May 7, 2018

**Meeting Summary**

STIP Project U-5768, NC 49 from John Kirk Drive to I-485; Widening of Existing Roadway and Relocation of Back Creek Church Road; Charlotte, Mecklenburg County

*Meeting Purpose: To reach concurrence on Concurrence Point 1 – Purpose and Need and Study Area Defined and Concurrence Point 2 – Design Options for Detailed Study*

Attachments: CP2 Alternatives (Slide #31 from 11/16/17 CP1/CP2 Merger Meeting)
 Figure 1 Revised Study Areas and Possible CP2 Alternatives
 Figure 2 Nearby BCCR/ECR Projects (NC 49 to Rocky River Road)
 Supplemental CP1 and CP2 information (includes revised concurrence forms) (to be sent by USACE).

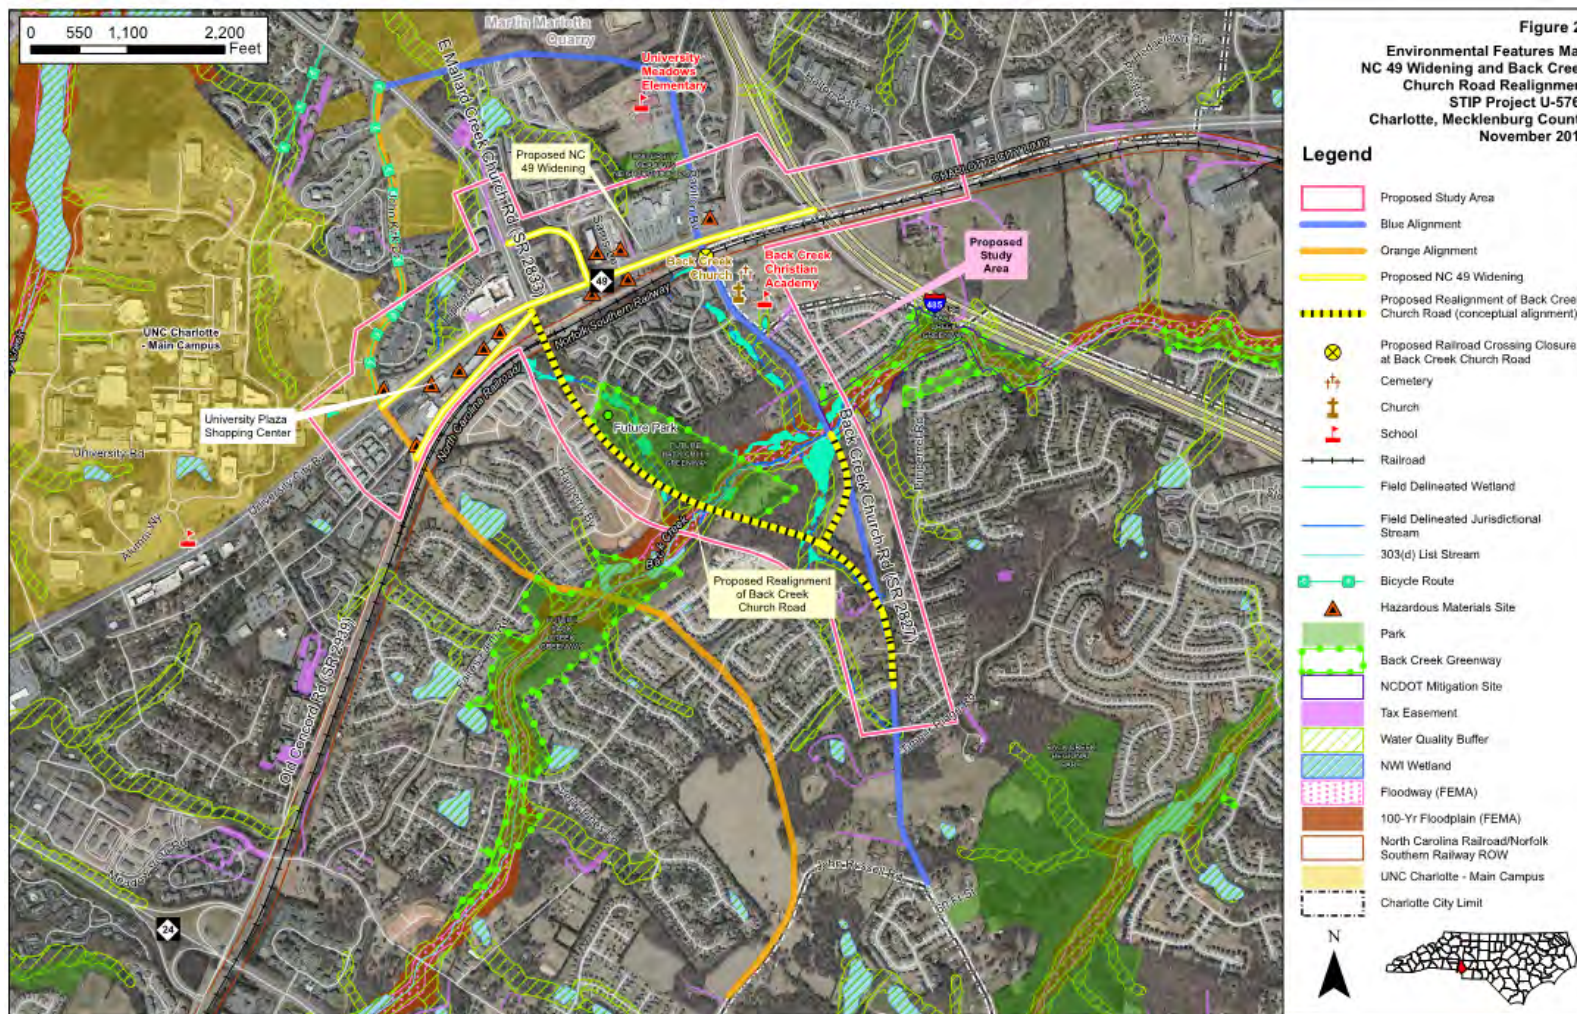
- USACE requested that additional written documentation be provided for the blue and orange options for to the proposed realignment of BCCR. It may be possible that these design options are screened out at CP 2; however, it was agreed that more supporting information is required to demonstrate whether these alternatives:

Figure X - Study Area Revision

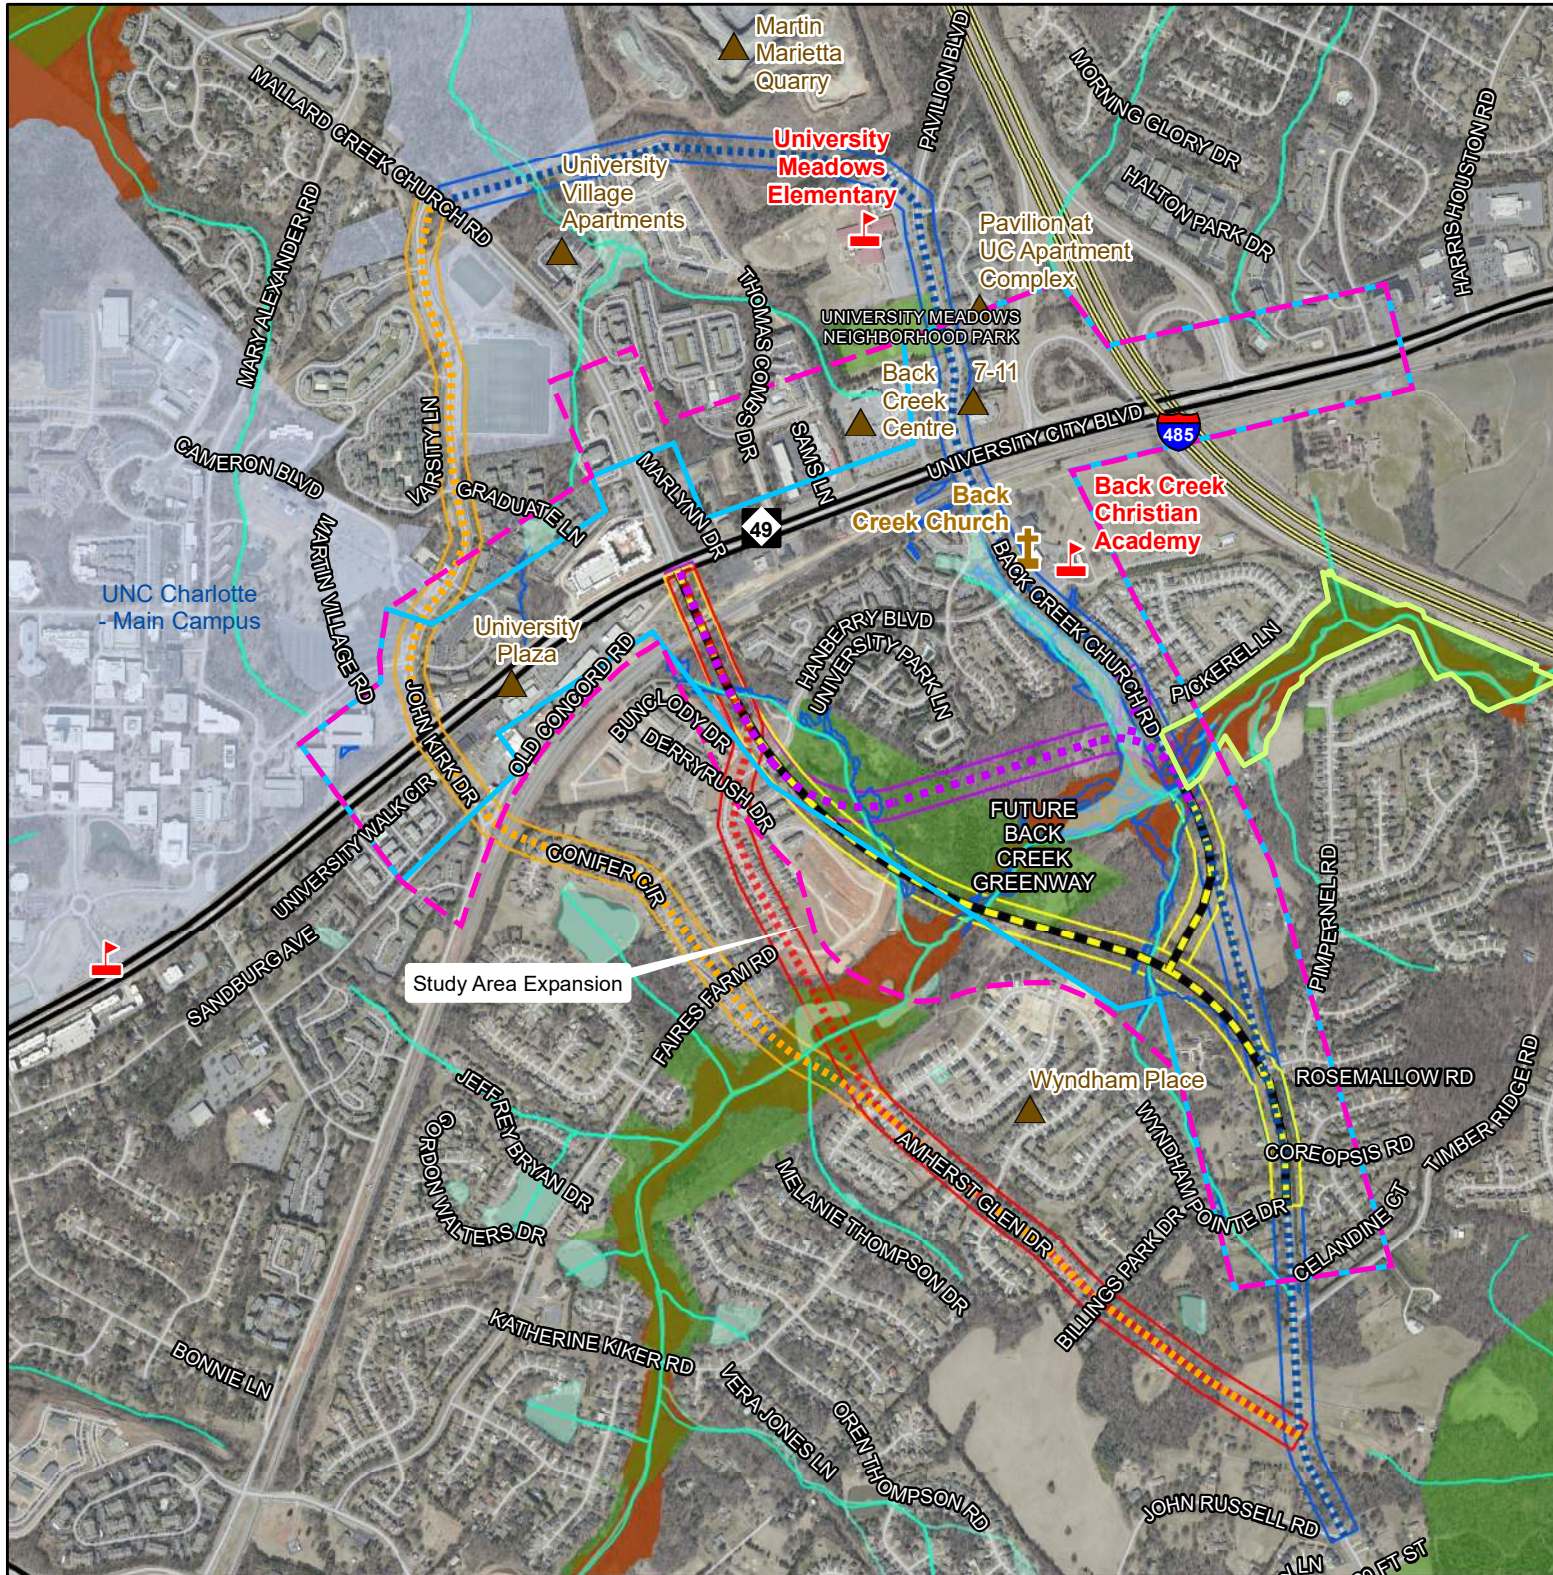
- The Merger Team acknowledged that the separation of train and vehicle traffic is an important component of the project.
  - The Merger Team reached verbal agreement on Purpose and Need.
  - **Update 11-17-17: USACE noted in a follow-up e-mail that the statement as revised during the meeting may be too specific and asked that it be changed to “maintain connectivity within the existing road network.” The CP1 concurrence form has been revised accordingly (see attached supplemental information).**
- Study Area
- NCWRC requested a slight expansion of the proposed study area to the west to allow for a potential reduction in stream impacts along Back Creek, as related to the proposed realignment of BCCR. **Post meeting note: The study area has been expanded, per this request (see attached, Figure 1).**

- USACE requested that the orange option be revised to tie to existing BCCR, rather than tying into John Russell Road.
  - o CDOT requested that the orange option tie to existing BCCR north of the BCCR widening project that is currently under construction by CDOT (see

- It was suggested that a “crossover” alternative for the realignment of BCCR be considered that would follow the yellow option north of Back Creek and the orange alternative south of Back Creek. **Post-meeting note: A new option (red option) has been developed for this concept (see Figure 1 in the attached supplemental information).**

attached BCCR/ECR graphic). **Post-meeting note: The orange option has been adjusted to tie to existing BCCR south of Timber Ridge Road, to avoid impacts to the retention pond north of Back Creek, and to reduce impacts to residential neighborhoods (see Figure 1 in attached supplemental information).**
